The Member-Secretary,
Madras Metropolitan
Development Authority,
No.8, Gandhi-Irwin Road,
Egmore, Madras-600 008.

Lr.No. B1/20239/90

Sub: MMDA - Planning Permission - Additional
construction of Second floor at Door No.16,
Vijayalakshmi Street, Madras-34 - Approved.

GROUND FLOOR PLAN

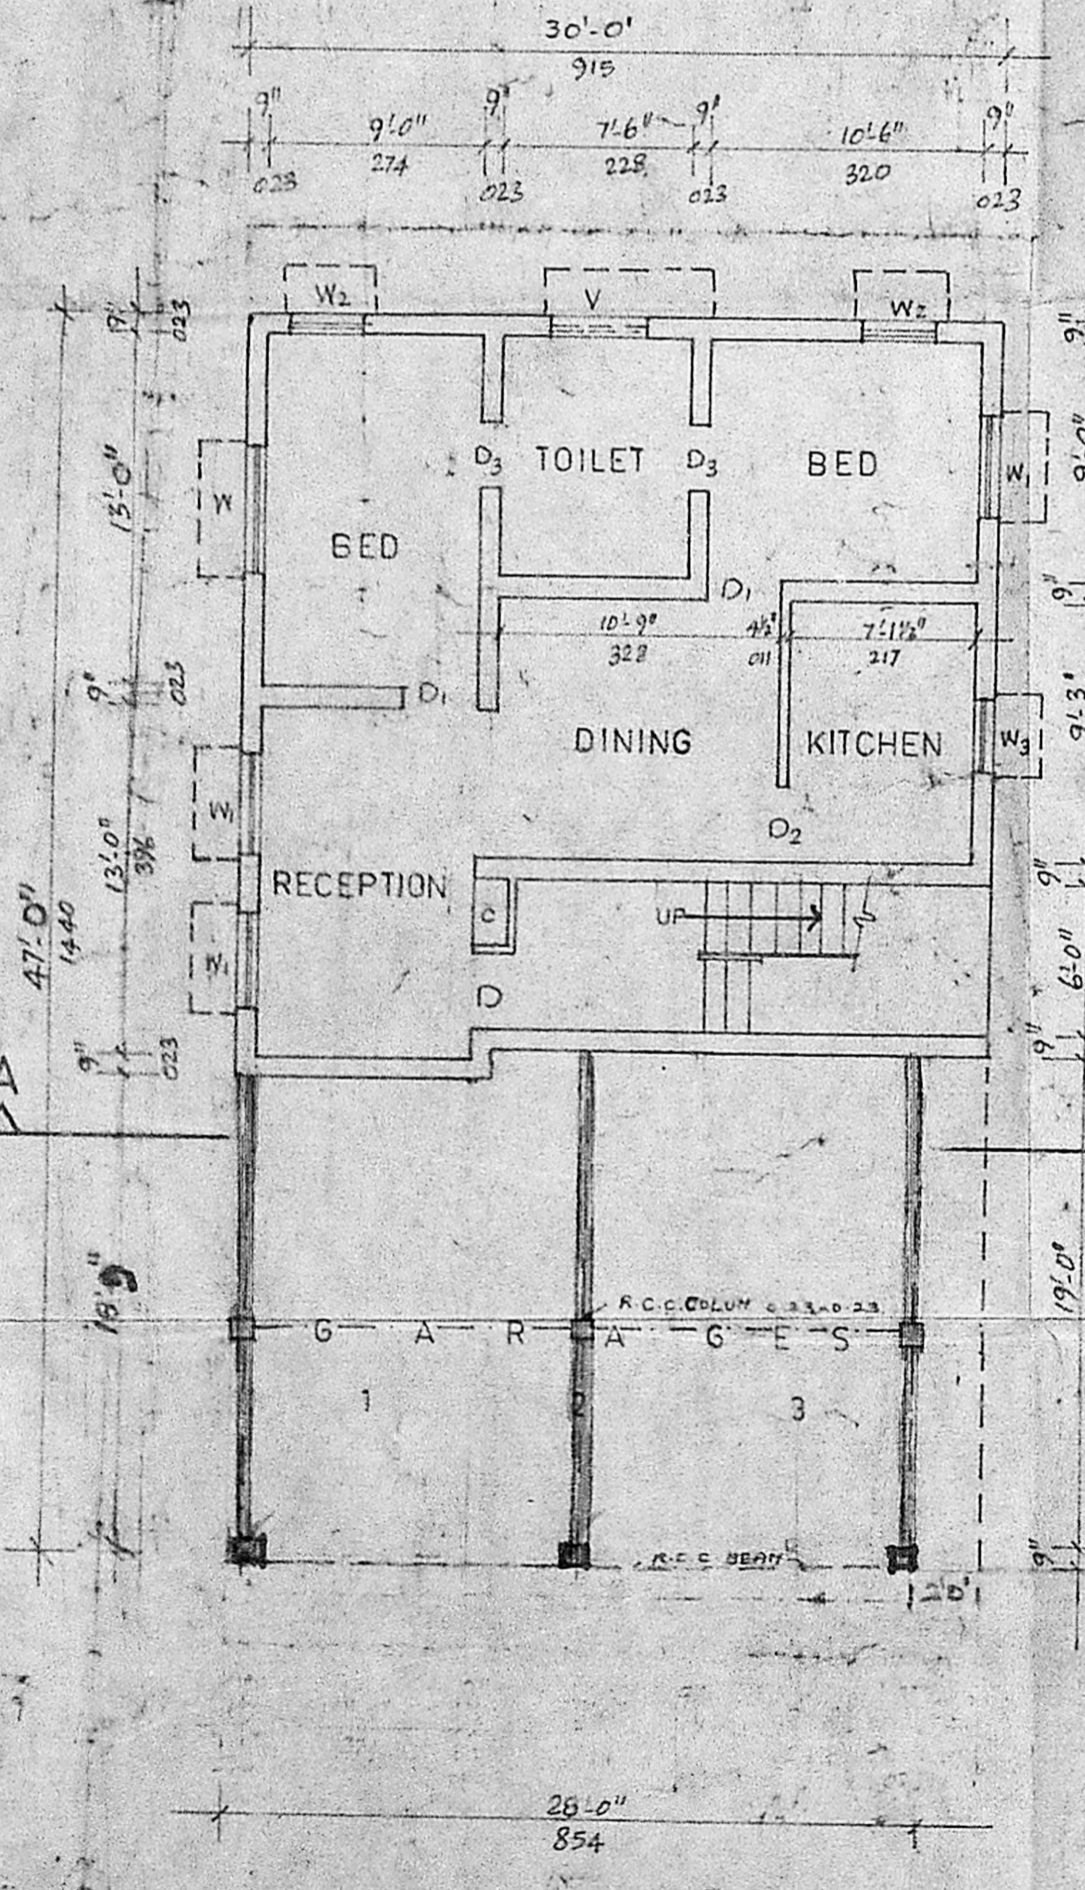
The planning permission application received in the refer-
ence cited for the additional construction of Second floor at No.16
Vijayalakshmi Street, Mahalingapuram, Madras has been approved
subject to the conditions incorporated in the reference second
cited and subject to demolition of violating Balcony projections
in First Floor and Second floor and walls inside the carparking
area of Ground floor within a period of 3 months.
